CITY OF ALBUQUERQUE

February 27, 2025

**RE: Savio Ridge Subdivision
9601 Tierra Pintada NW
Grading and Drainage Plan and Drainage Report
Engineer's Stamp Date: 01/24/25
Hydrology File: J08D003B
Case # HYDR-2025-00009**

ZONE MAP NO.
J-07-Z, J-08-Z
CITY PROJECT NO.
—
SHEET NO. 1 OF 9

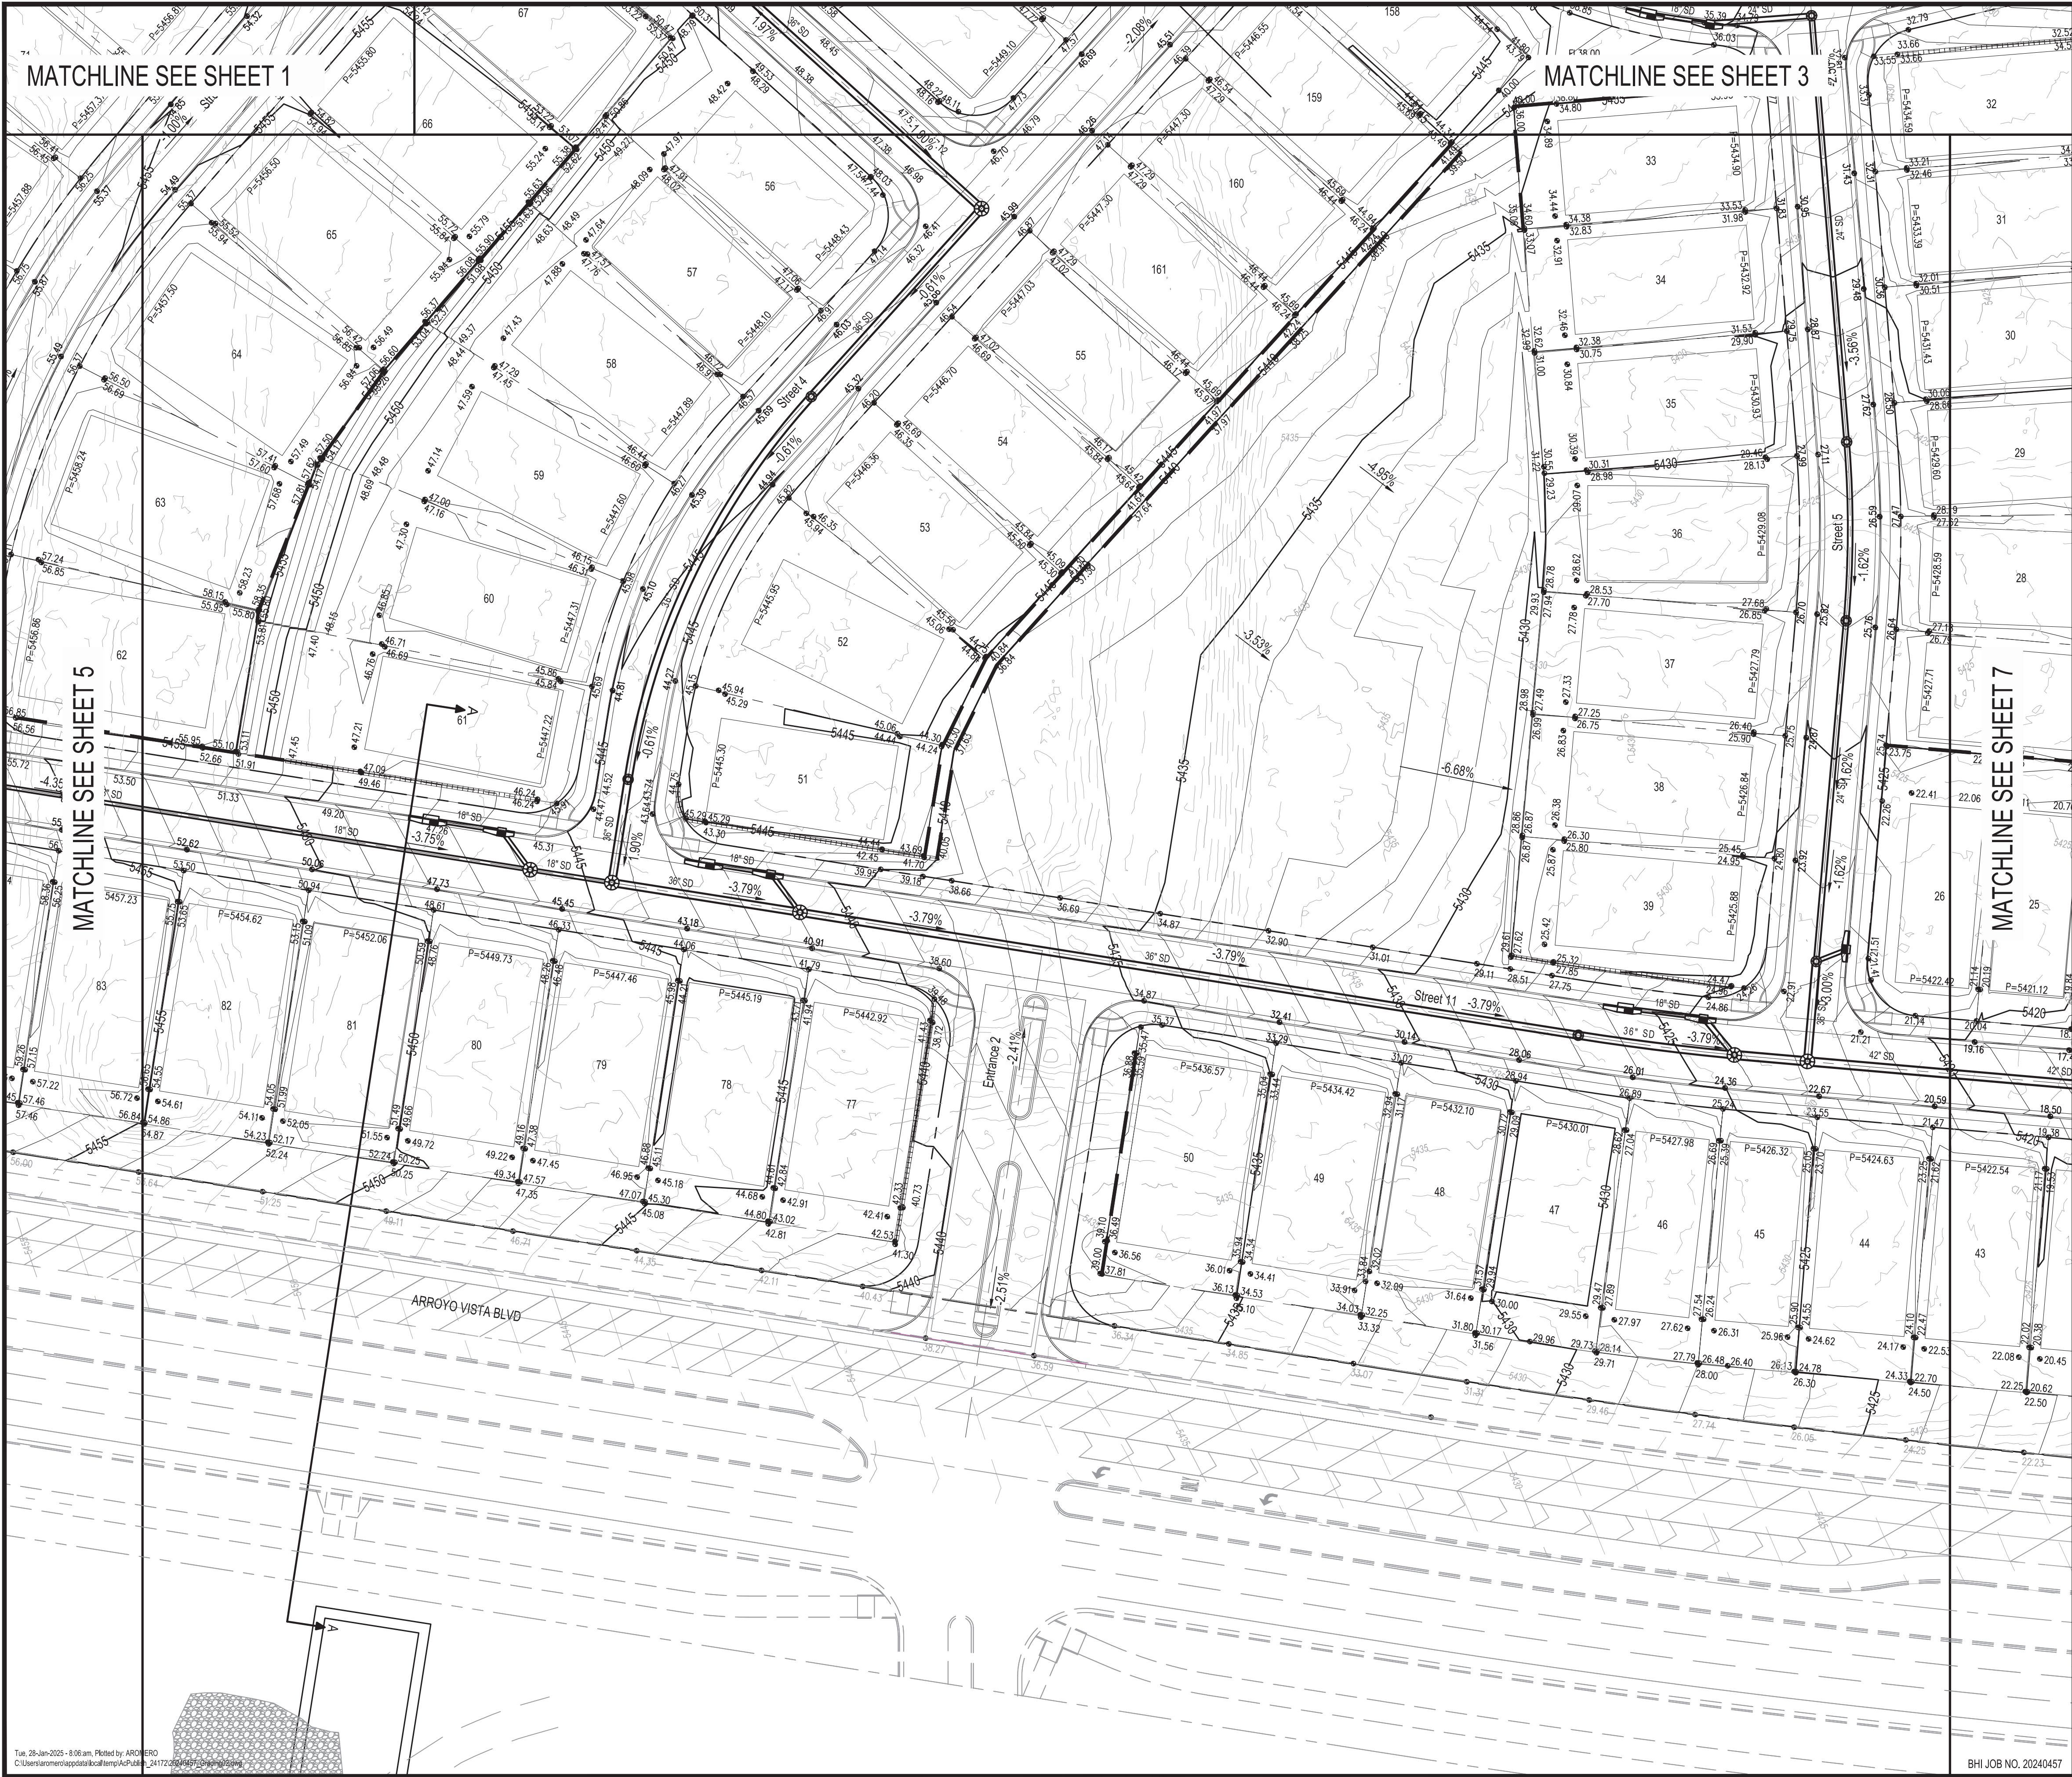
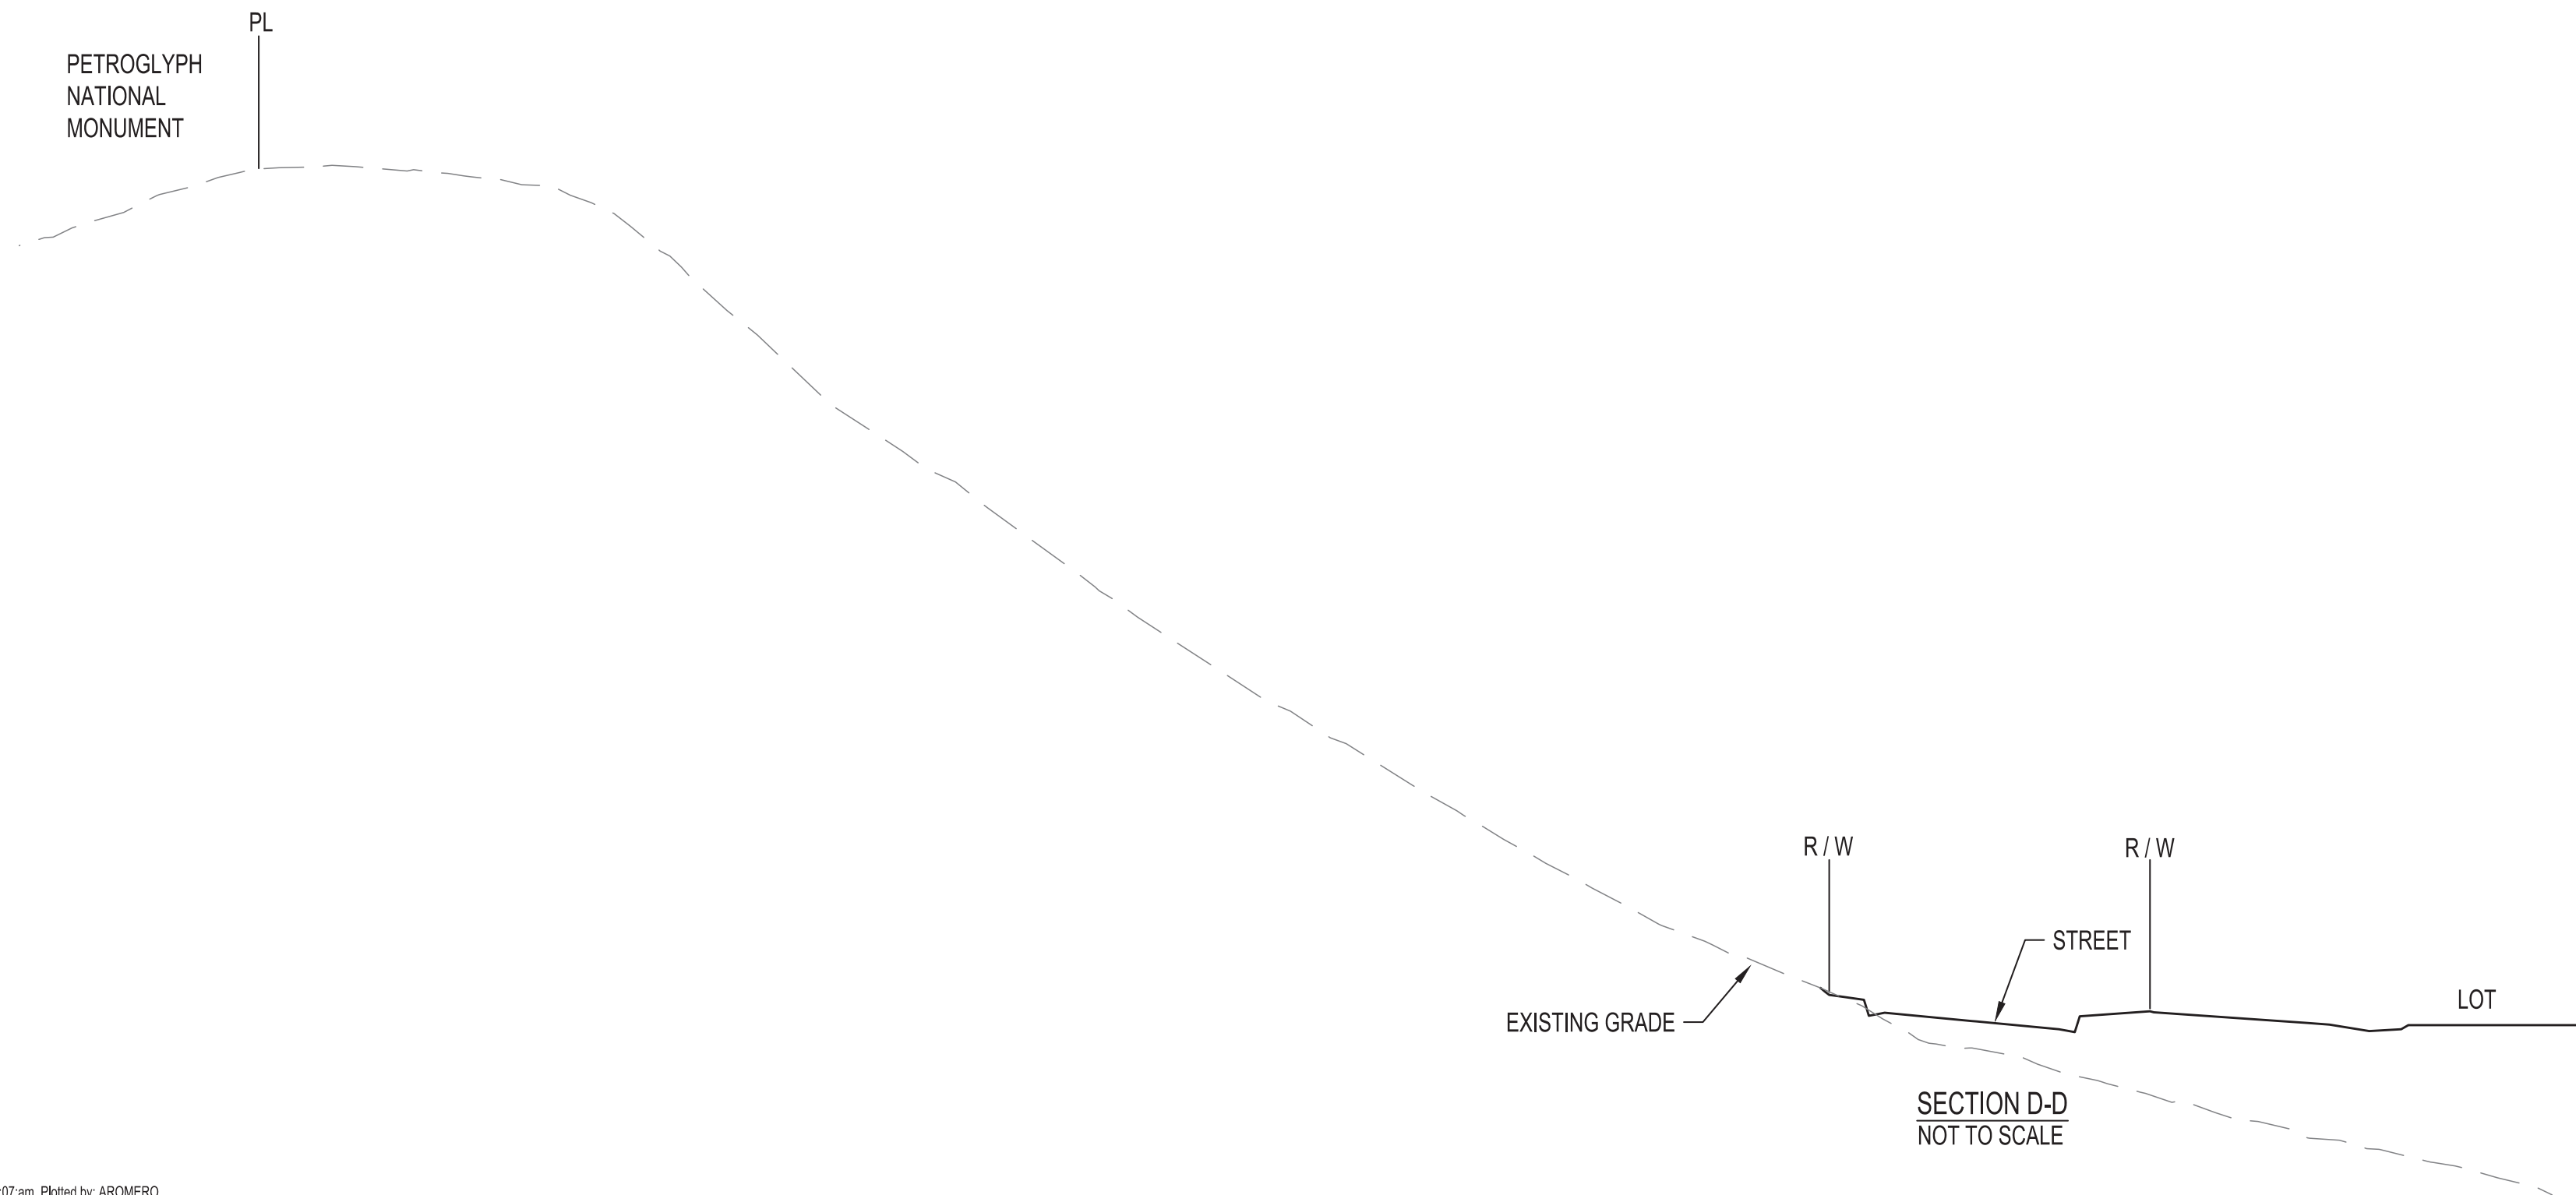
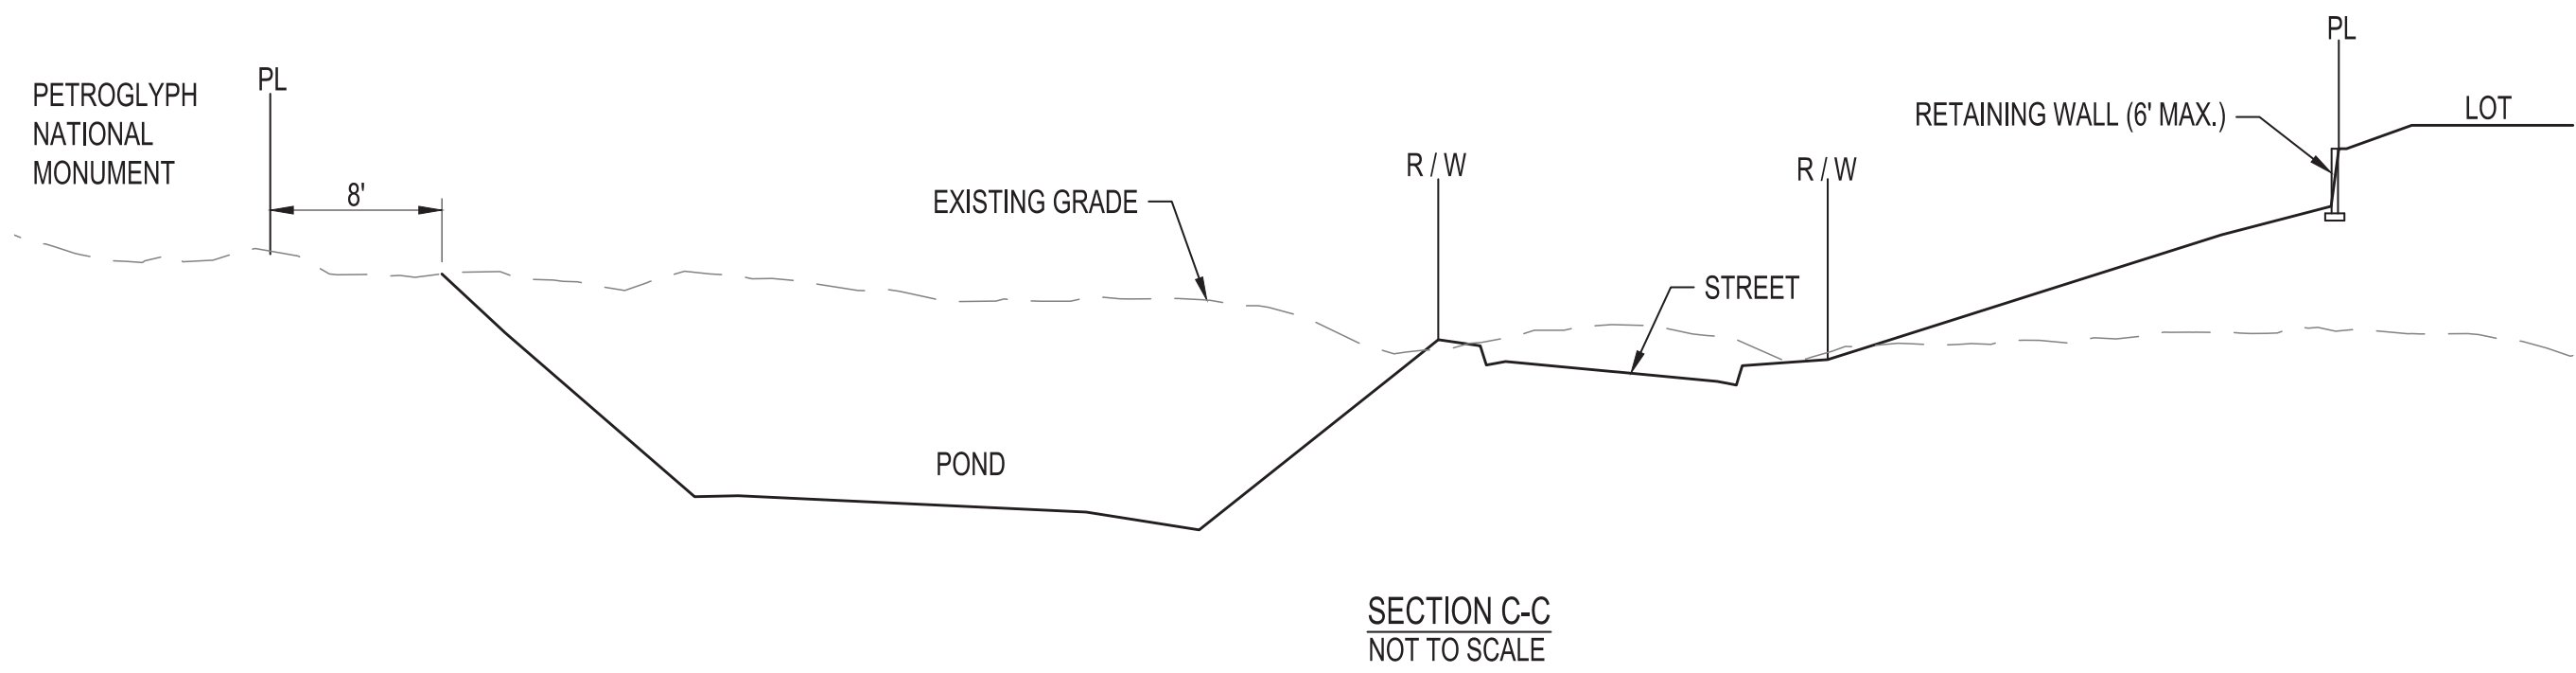
1. Since this project is adjacent to, or drains into an Albuquerque Metropolitan Arroyo and Flood Control Authority (AMAFCA) facility, approval by AMAFCA will be need prior to Hydrology approval. Please contact Jared Romero P.E, CFM (jromero@amafca.org or 505-884-2215).
2. Per the DPM, the following must be on the Grading Plan. Please note the Grading Plan must be a stand-alone construction document.
 - a. Please provide a Vicinity Map. This can be downloaded in pdf format from the City of Albuquerque's website.
 - b. Please provide the FIRM Map and flood plain note with effective date.
3. Please add a note on the Grading Plan to reference the Drainage Report for details related to the project conditions, requirements, and calculations.
